Report of the Head of Development Management and Building Control Committee Report Part 2 – Application Report

Case Officer: Samuel Patten	79950/APP/2026/575
------------------------------------	---------------------------

Site Address: **107 Newdigate Road East, Harefield, UB9 6ES**

Proposal: **Rebuilding of single storey store with cavity wall and increasing height to create wet room.**

TITLE:
 Proposed Ground Floor Layout

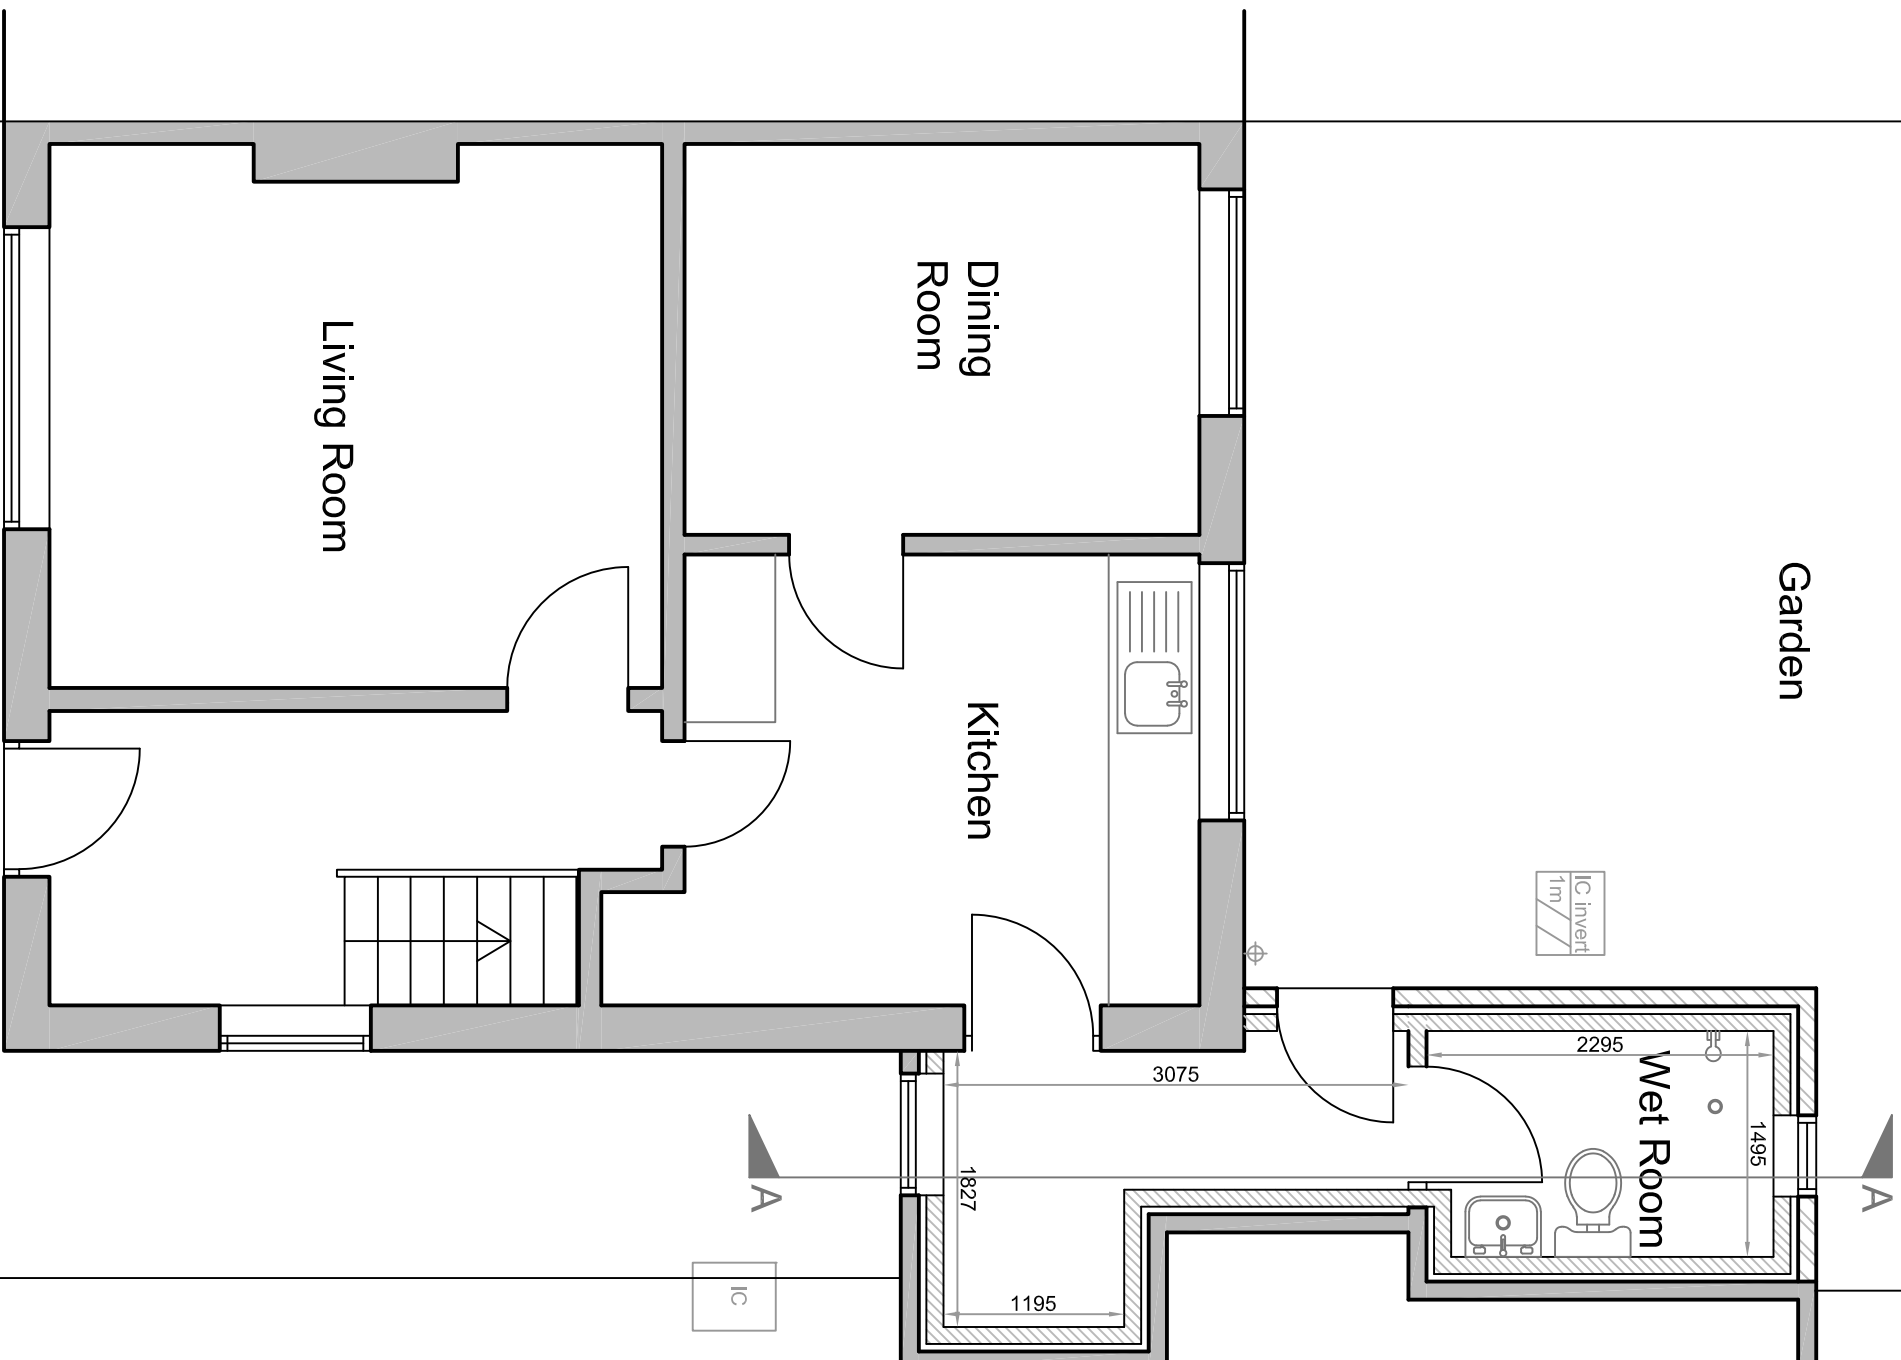
- 3.1** Planning permission is sought for the rebuilding of single storey store with cavity wall and increasing height to create wet room. The proposal will replace an existing store of similar footprint. The relevant dimensions of the proposal are listed below.
- 3.2** Existing Store
Depth – 6.00m
Width – 2.00m
Maximum Height – 1.25m

3.3 Proposed Shower Room
Depth – 6.00m
Width – 2.00m
Maximum Height – 2.85m

- 7.5** The proposal being assessed involves the partial demolition of the existing attached store located to the rear north-eastern corner of the property, in order to rebuild the structure with a flat roof and insulated walls for use as an accessible wet room. The footprint and size of the structure would not be significantly different to what is already existing on site, with the proposed maximum height being 2.85m compared to the current 2.50m. The location of the structure to the area of the property also reduces its potential impact upon the character and appearance of the wider street scene. The proposed materials will be matching or similar to those of the existing store and dwellinghouse, and the similar appearance of the materials will be secured by condition to ensure compliance for the lifetime of the development.

TITLE:
 Proposed Elevations and Section A - A

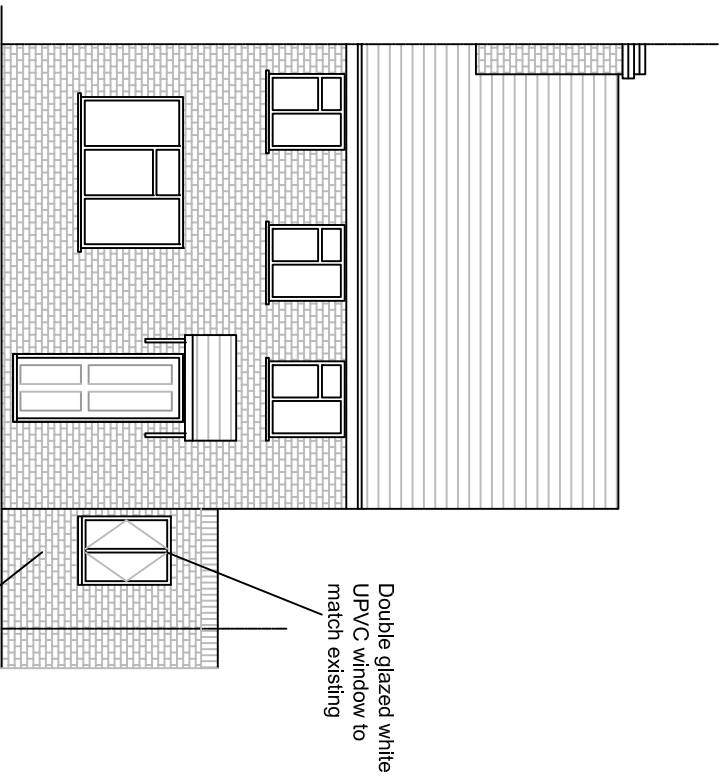
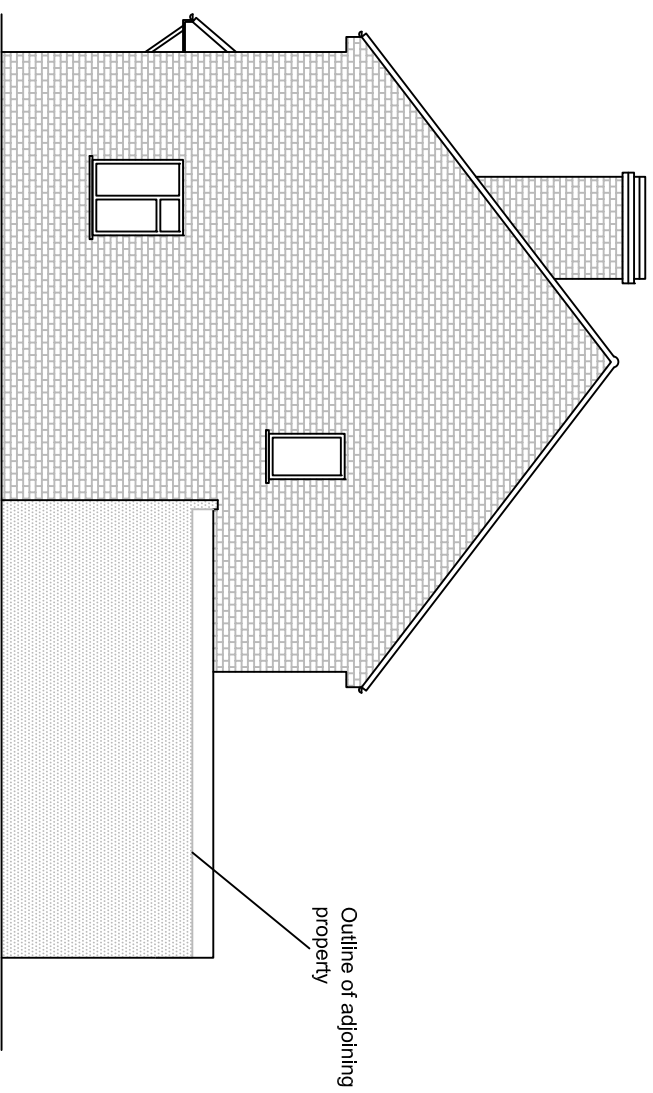
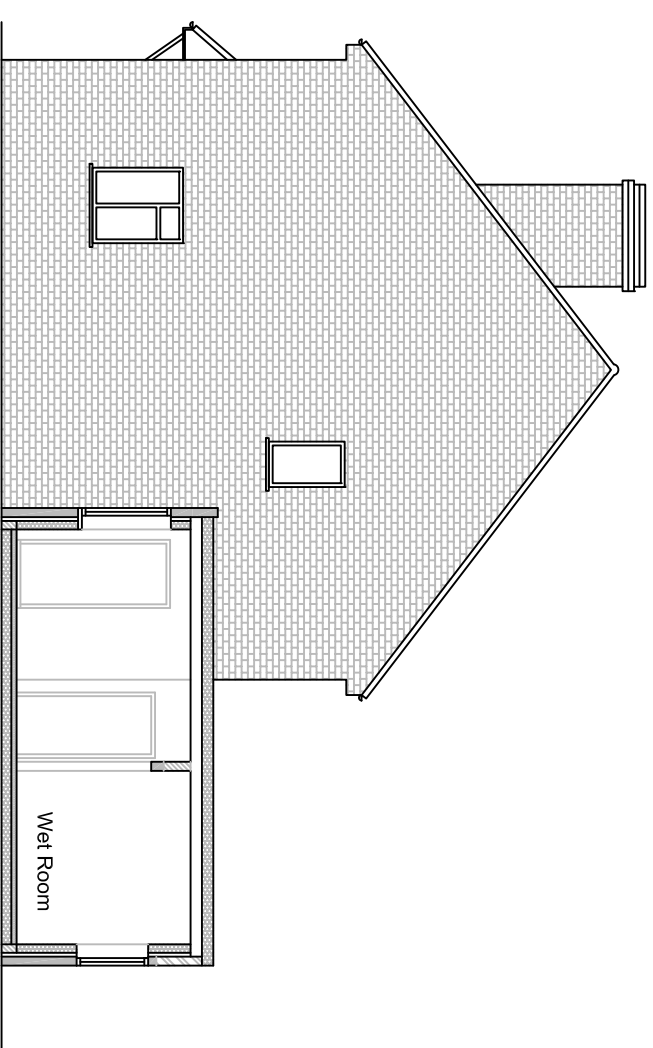
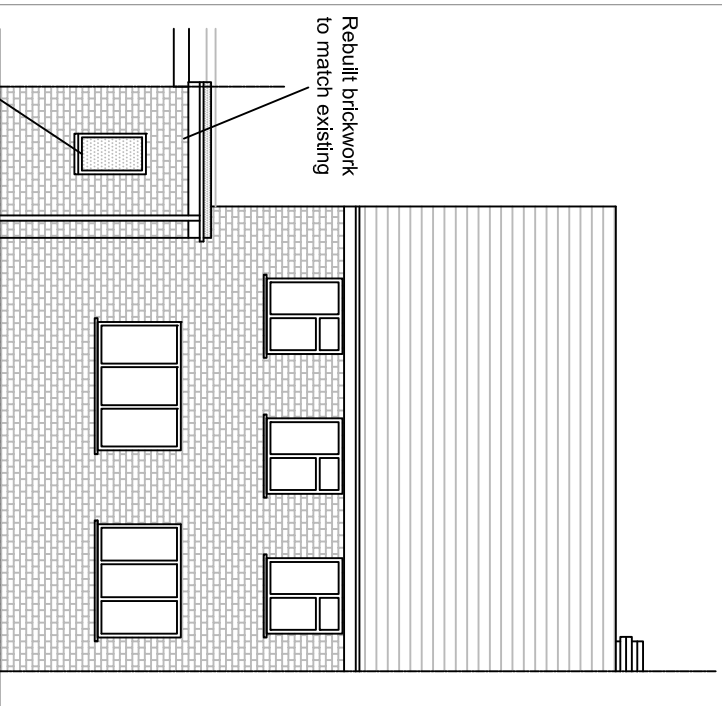
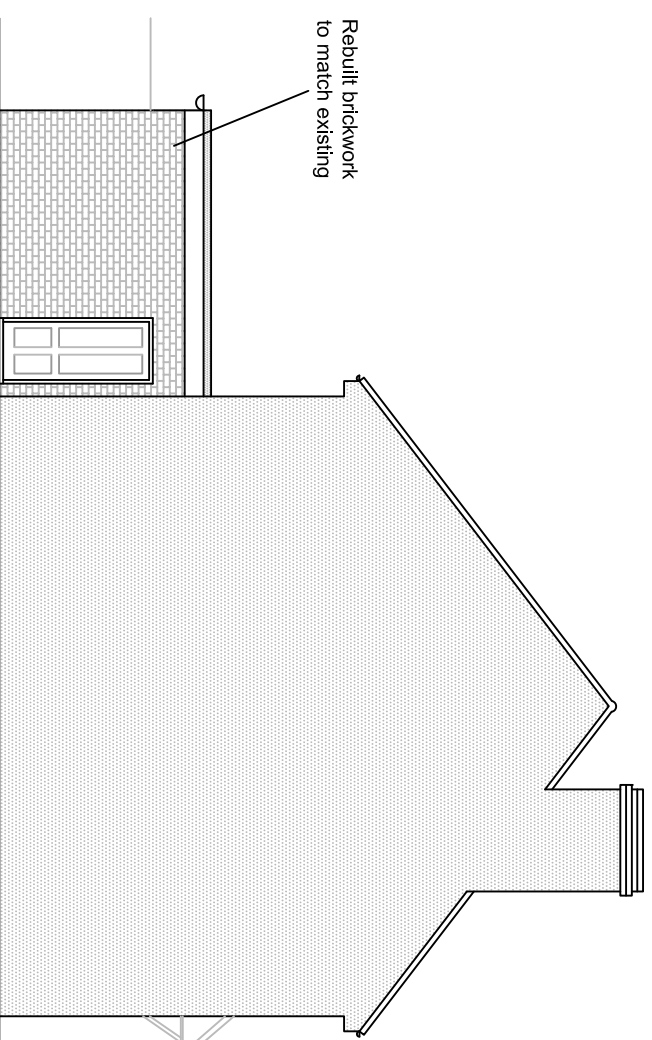
Access to the flat roof over the extension hereby approved shall be for maintenance or emergency purposes only and the flat roof shall not be used as a roof garden, terrace, balcony, patio or similar amenity area.
